The exhibit A plan is what is built today. The energy dissipator plan is the proposed plan. I had comments on it. Figured they should knock some holes out of the sides to spread the flows over a larger area.

Subject: Sundance Phase IA & IB - Exhibit A

Attached is the original Exhibit A that was agreed to, as well as a final more revised drawing that we had worked with Brad Bingham on to make the outfall structure fit more inconspicuously with the adjacent escarpment.

TITLE: **SUNDANCE ESTATES - PHASE 1-B**
ENERGY DISSIPATER

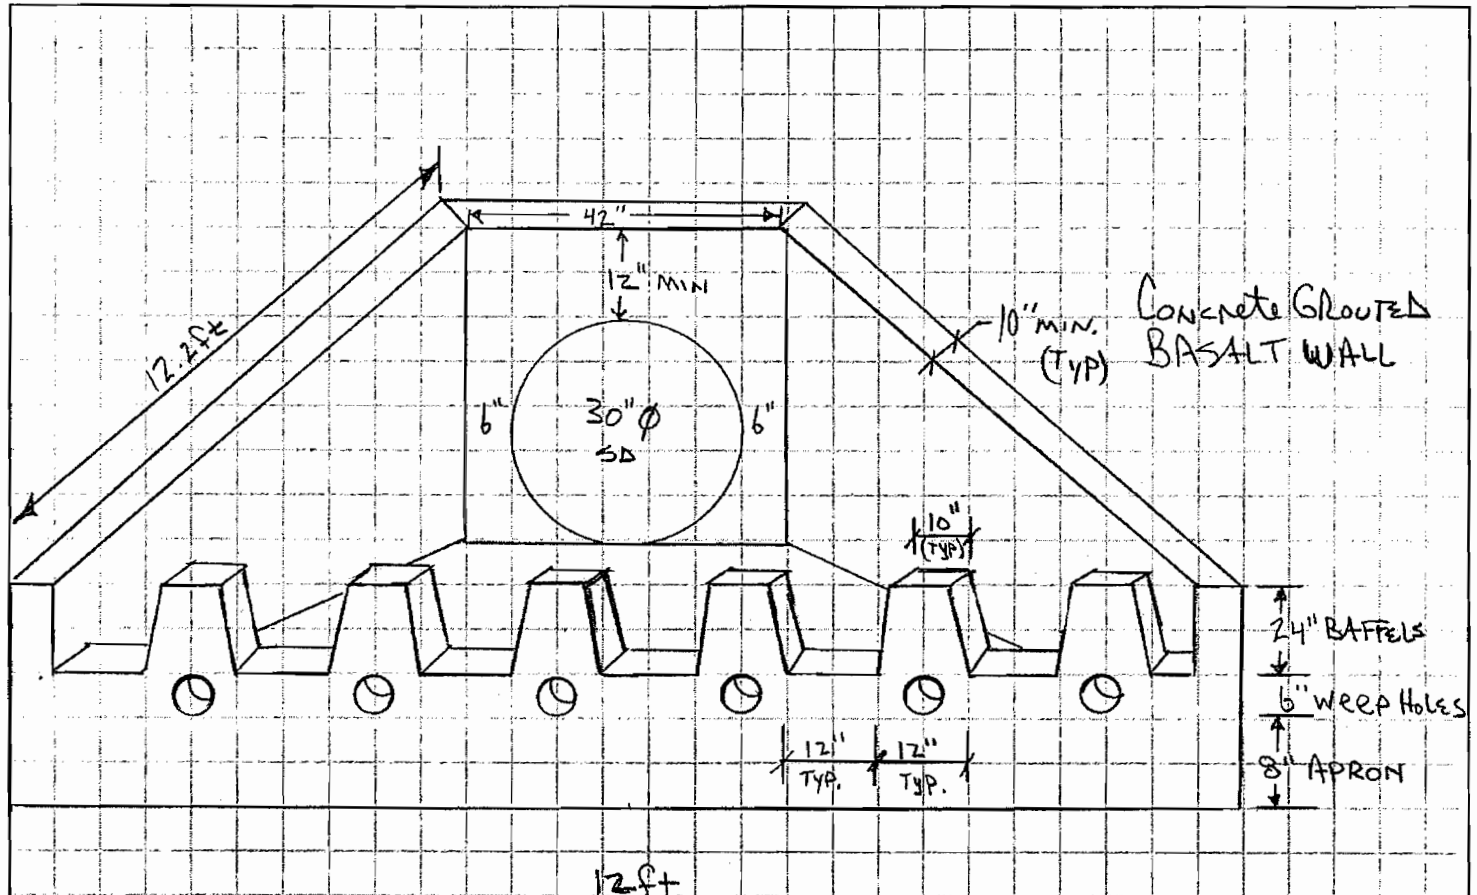
We also very much like your "...knock some holes out of the sides to spread the flows over a larger area..." idea.
